Our Ref: 1160-8-25

Your Ref: Stage 3 (SSD 57703458)

**Re: Regents Park In-fill Affordable Housing – Stage 3 (SSD 57703458)
Response to submissions – Traffic.**

FIGURE 7A HRV RHT INTO RW2
REVERSE ENTRY INTO DOCK E

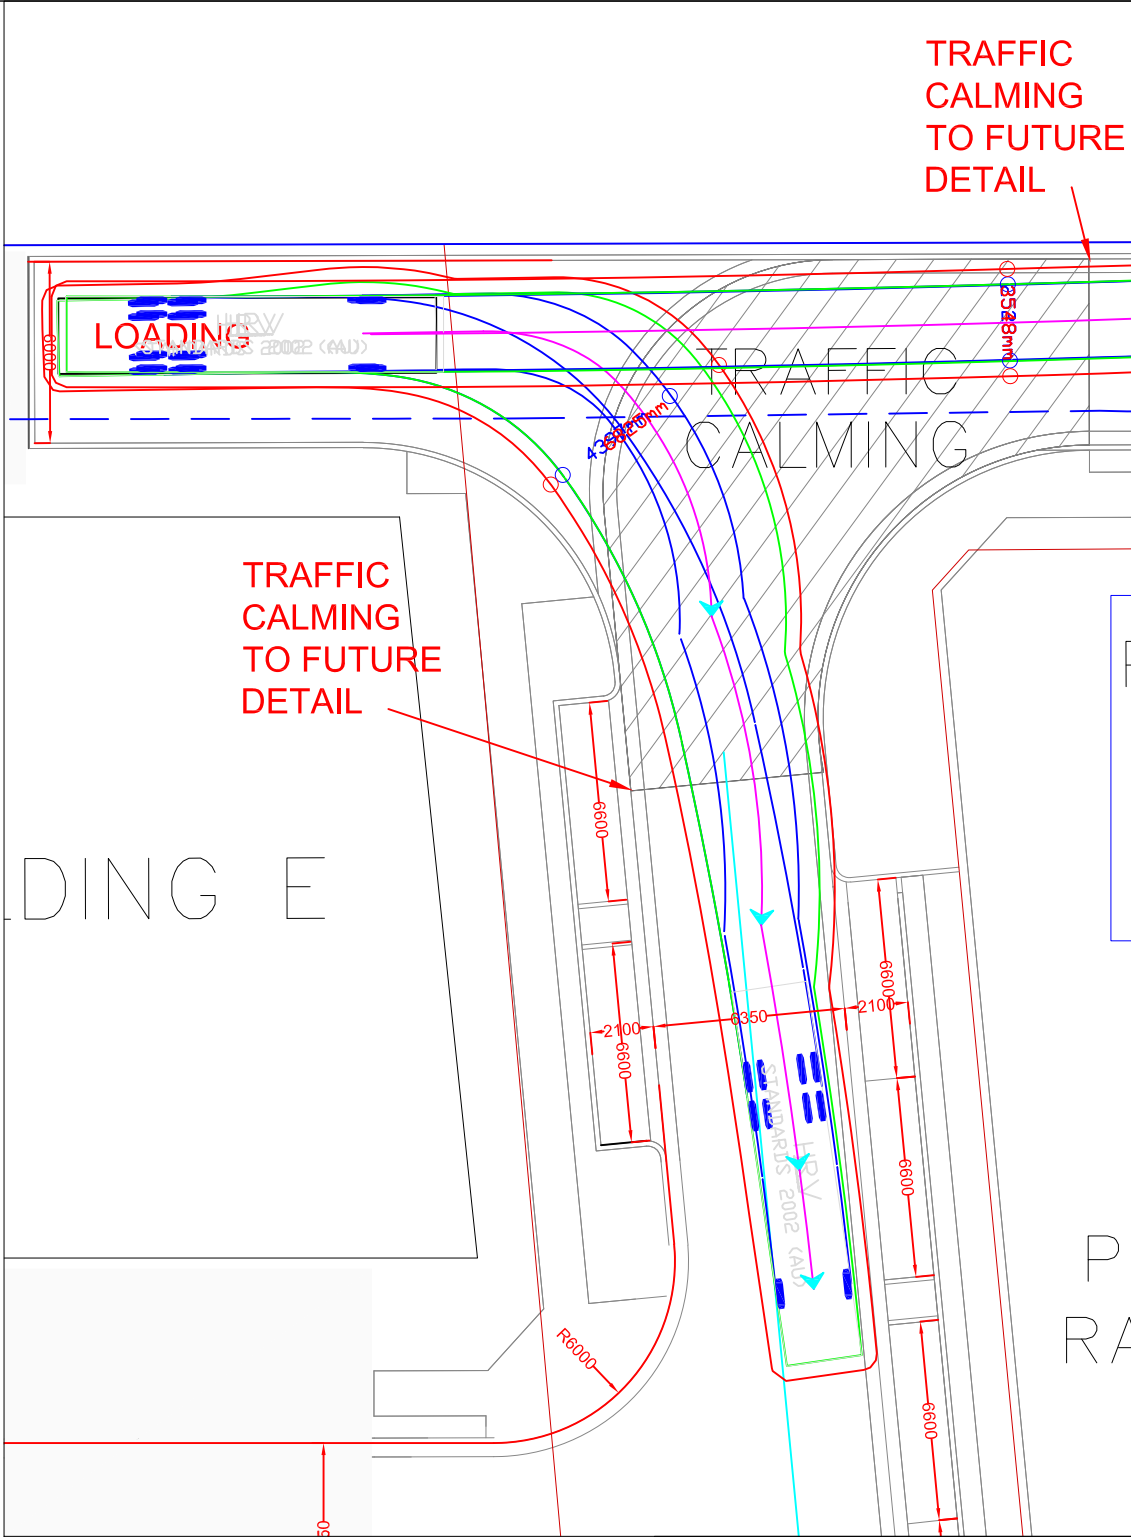
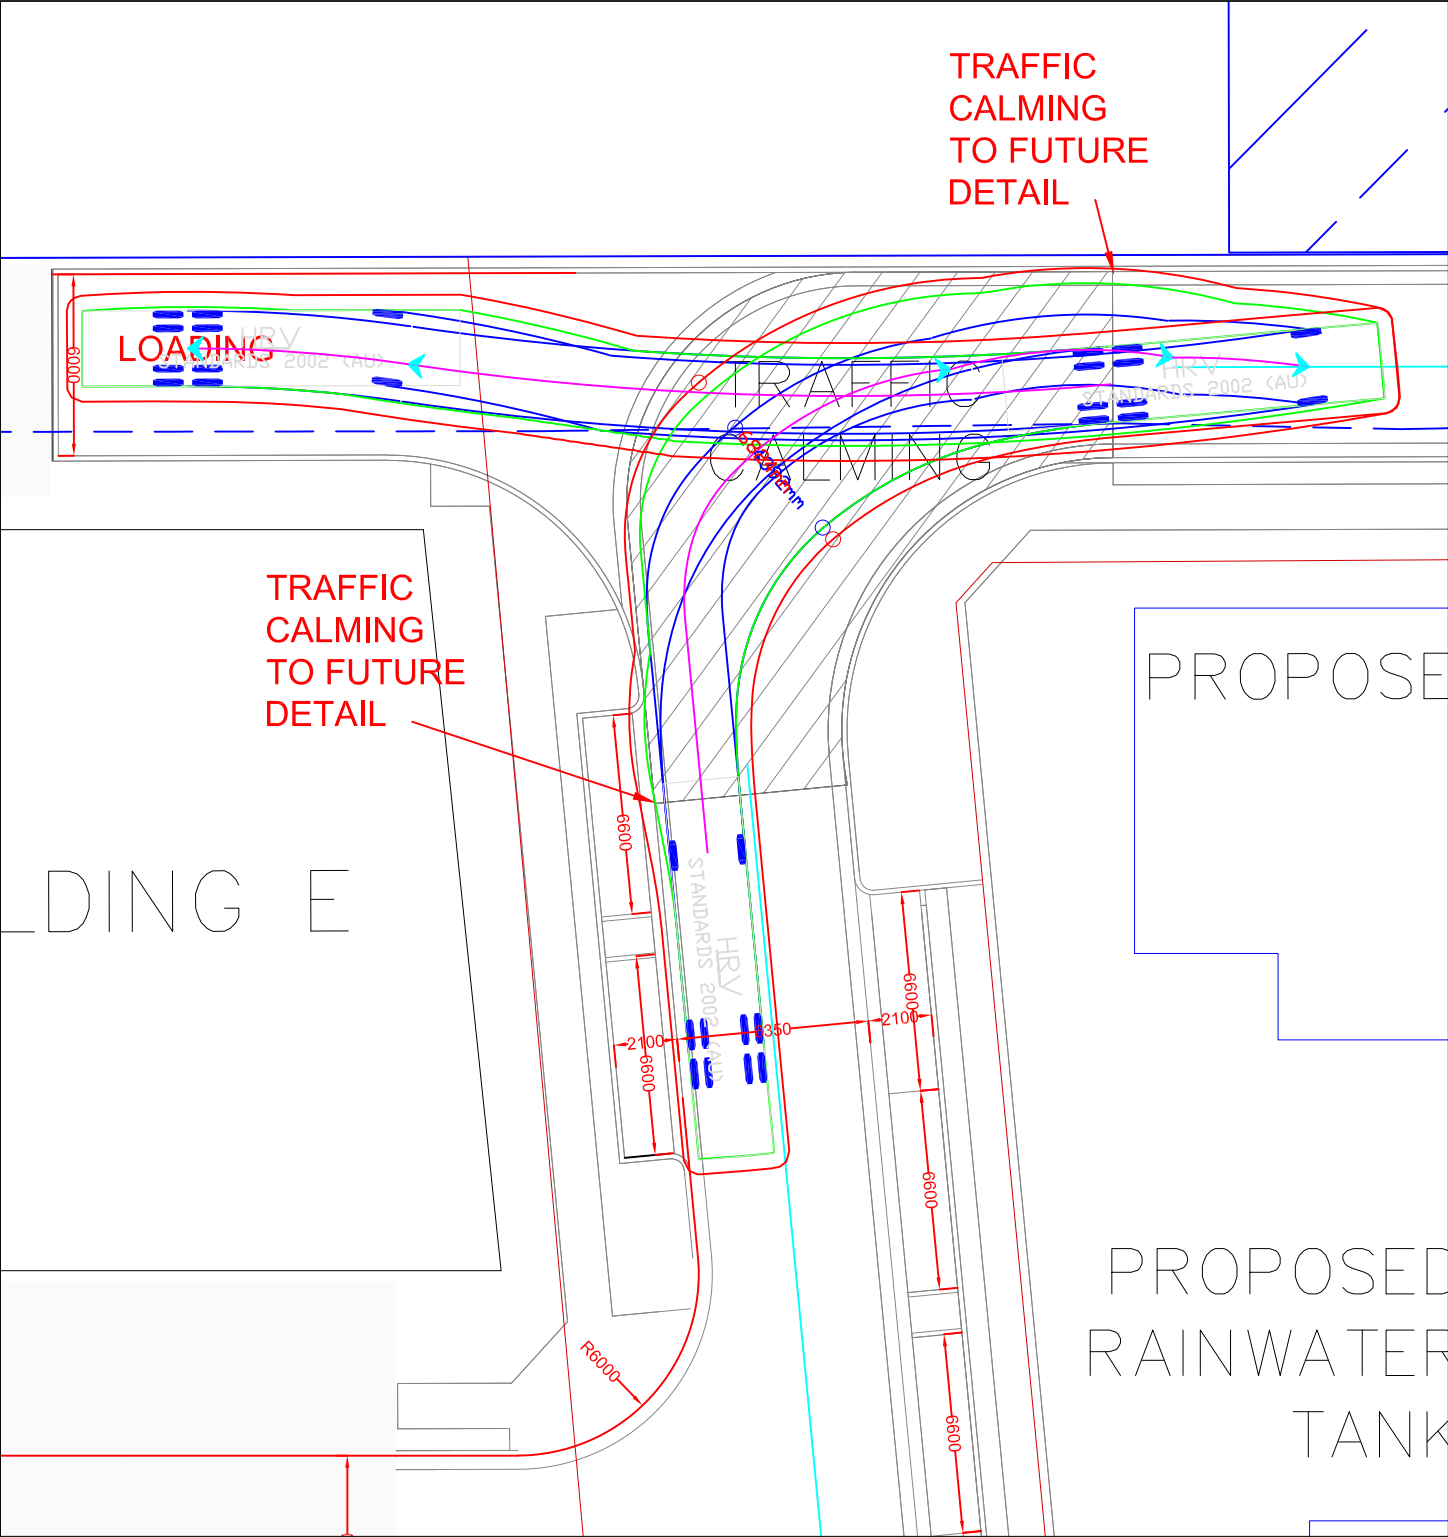
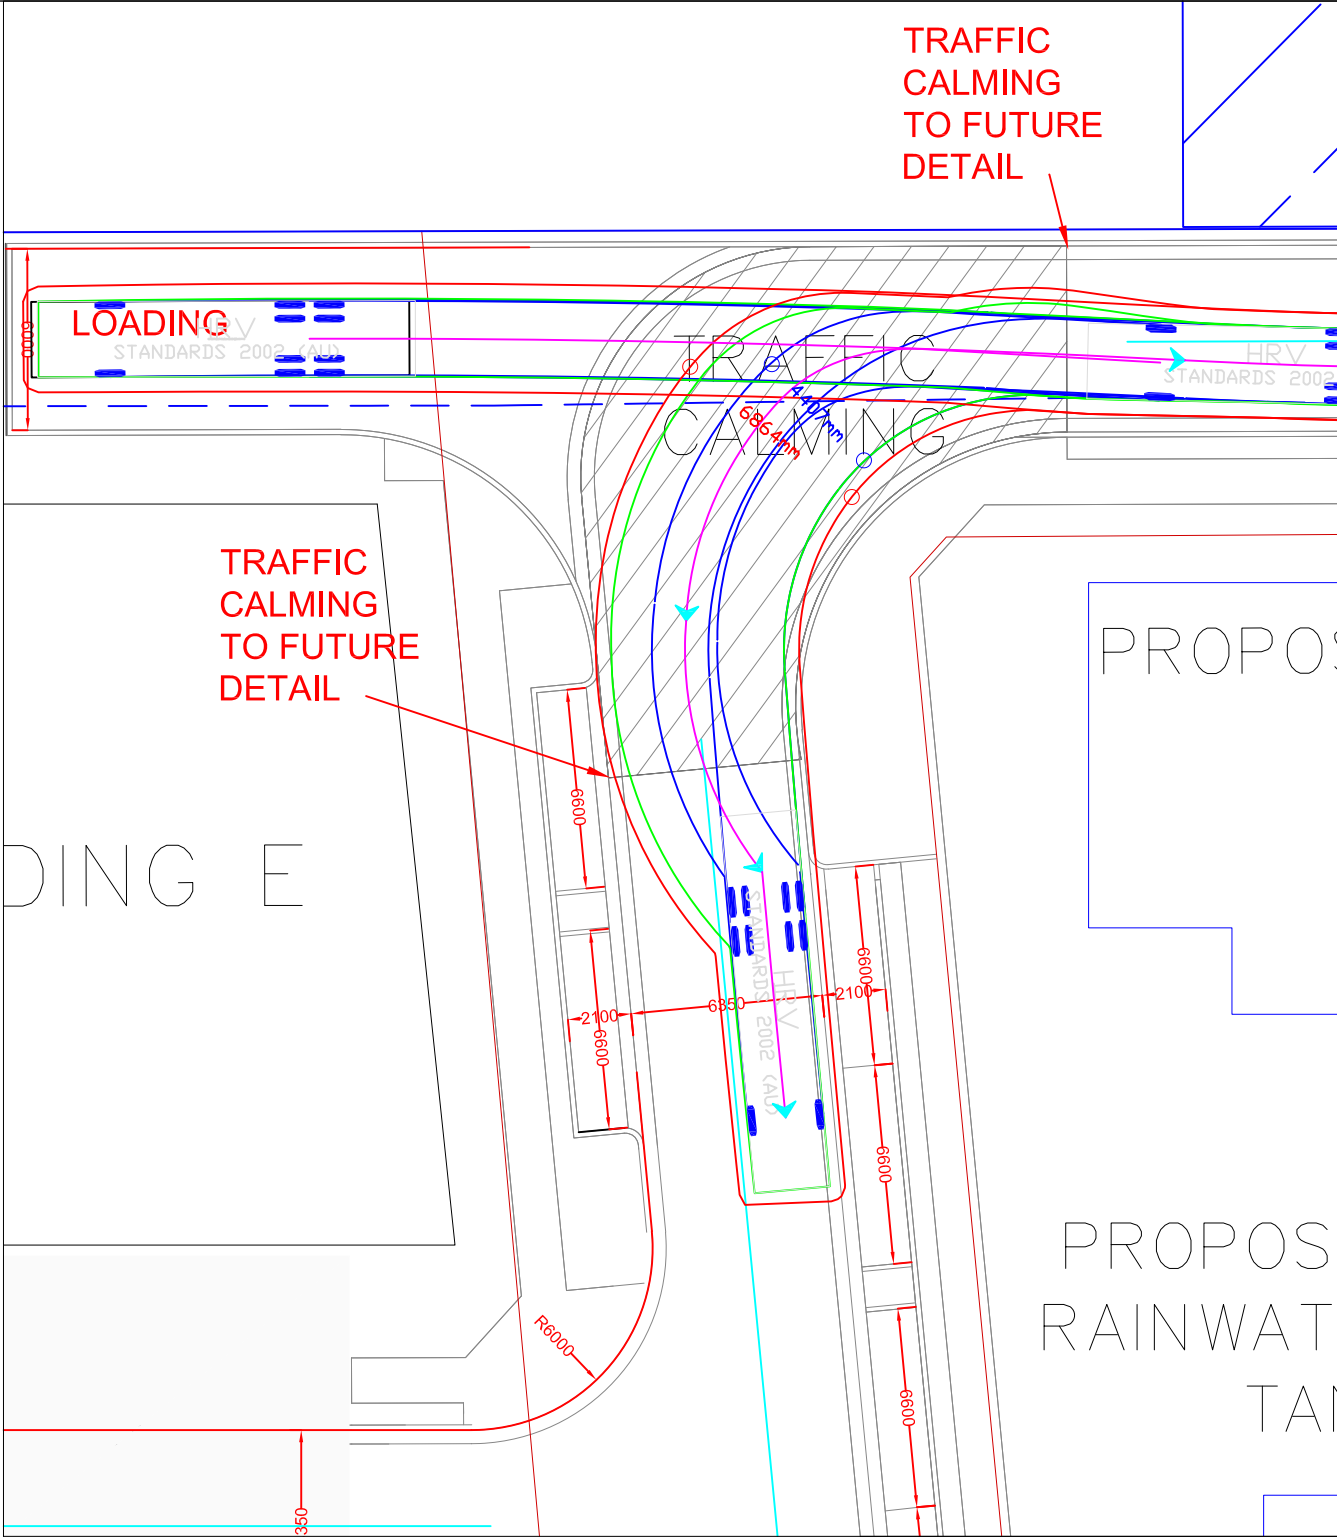
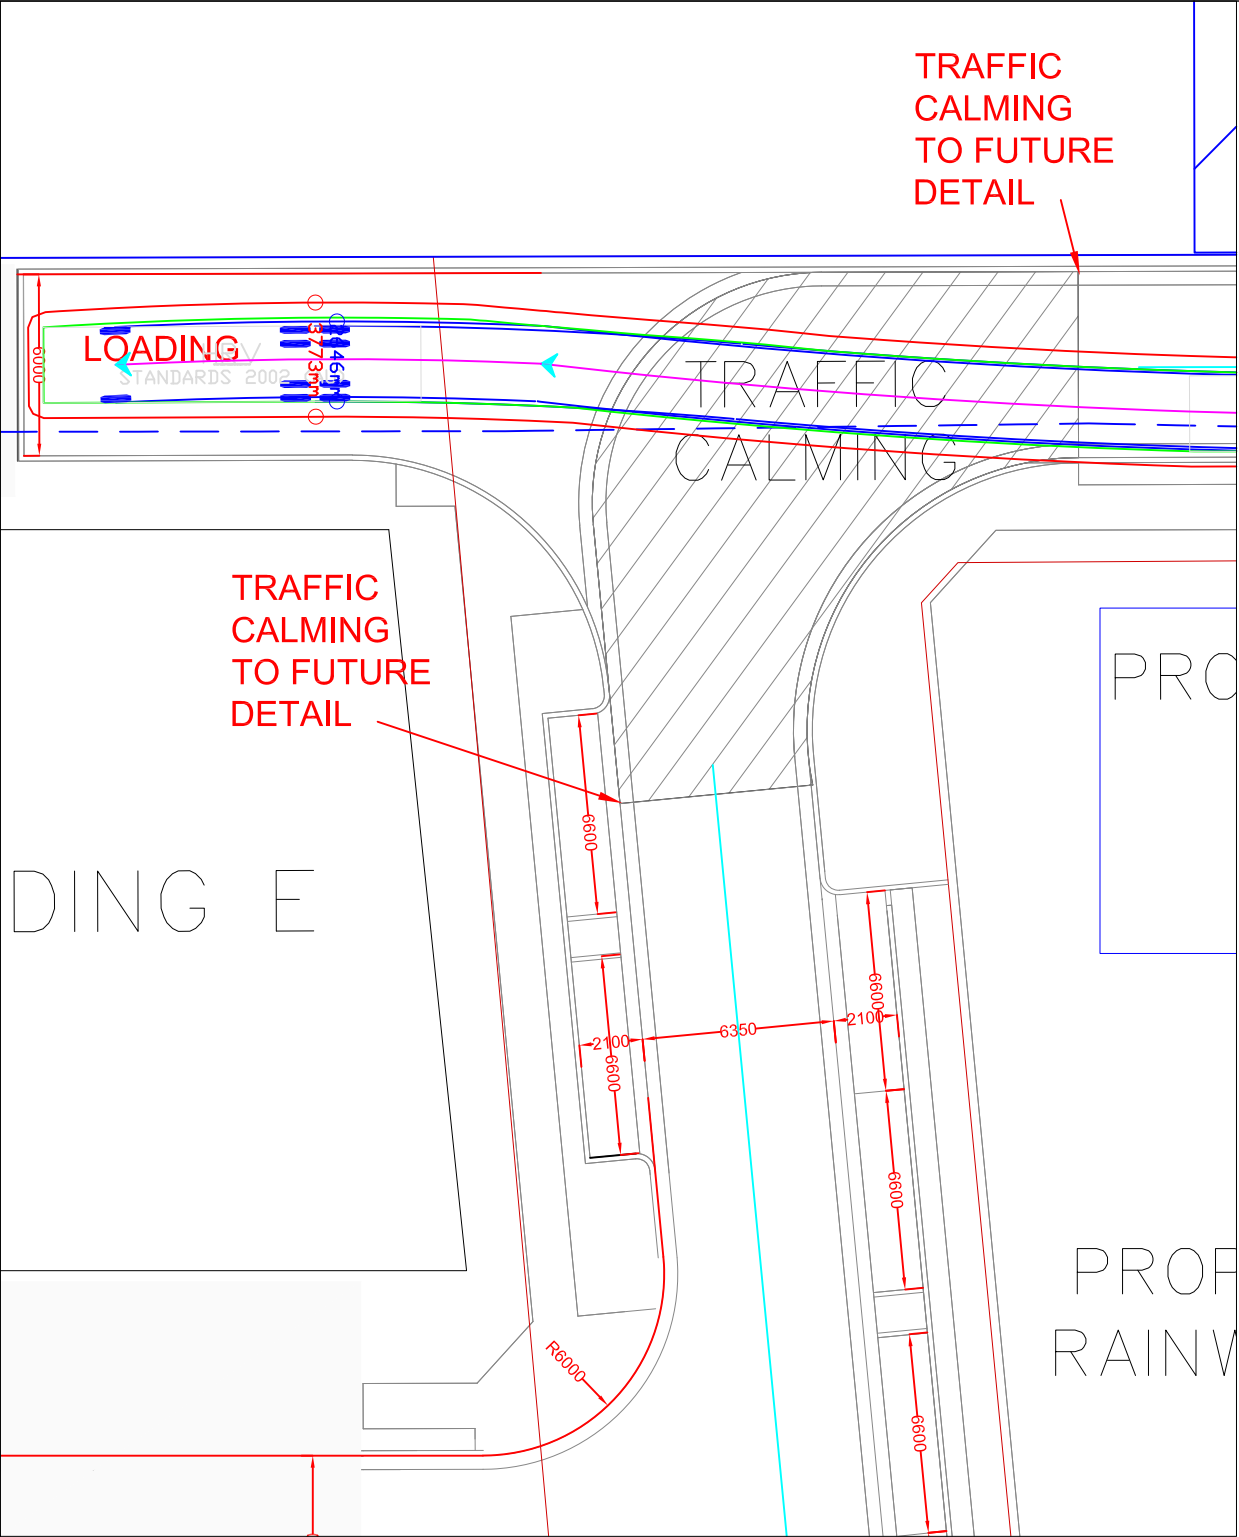
The Transport Impact Assessment and Waste Management Plan (WMP) does not provide swept paths for on-site collection by a Heavy Rigid Vehicle (HRV) or identify the travel paths from the basement waste storage to the waste collection point. The WMP advises that cleaners will be responsible for transporting waste to the collection points. Please provide:

- swept paths for waste collection vehicles
- travel path diagrams from basement waste storage to the collection point
- a designated staff room
- cleaning storage facilities.

The Transport Impact Assessment and Waste Management Plans have both been updated to include swept paths for onsite collection of waste by HRVs.
